Commission Order
ABP-322821-25

Planning Authority: Limerick City and County Council

Planning Register Reference Number: EC/107/25

WHEREAS a question has arisen as to whether an extension to the rear of a dwellinghouse at 8 Clonmore, Kilteragh, Dooradoyle, County Limerick is or is not development or is or is not exempted development,

FLOOR PLAN & SITE LAYOUT PLAN

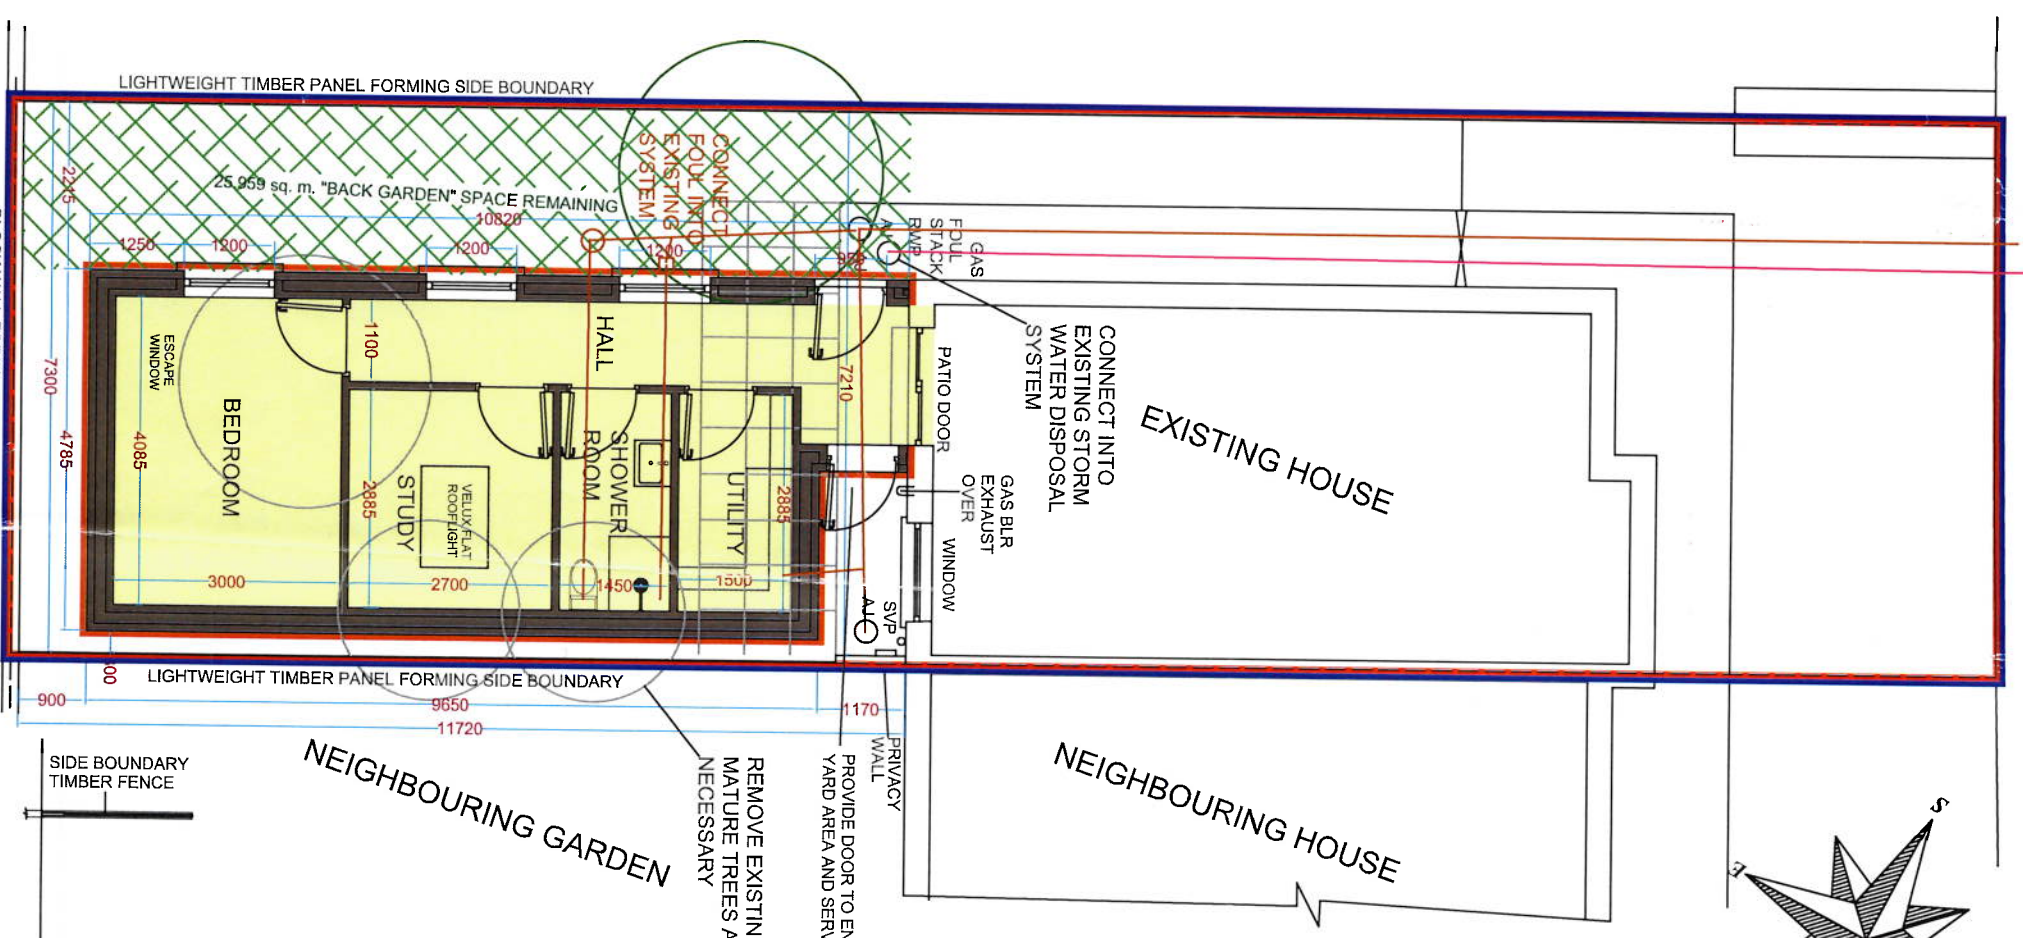
- (d) the floor area of the proposed extension does not exceed 40 square metres. Notwithstanding that there is an area of garden to the side of the proposed extension, the private open space, reserved exclusively for the use of the occupants of the house, remaining to the rear of the proposed extension would be reduced to less than 25 square metres,

- (e) the height of the extension does not exceed the height of the rear wall of the main house, and
- (f) the proposed extension, therefore, does not come within the scope of Schedule 2 Part 1 Class 1 of the Planning and Development Regulations 2001, as amended, as the private open space, reserved exclusively for the use of the occupants of the house, remaining to the rear of the proposed extension would

In deciding not to accept the Inspectors recommendation the Commission considered that the wording of Schedule 2 Part 1, Class 1, Condition and limitation 5 'The construction or erection of any such extension to the rear of the house shall not reduce the area of private open space, reserved exclusively for the use of the occupants of the house, to the rear of the house to less than 25 square metres' did not refer to the open space to the rear of the original house or provide for the open space to be located to the side of the extension.
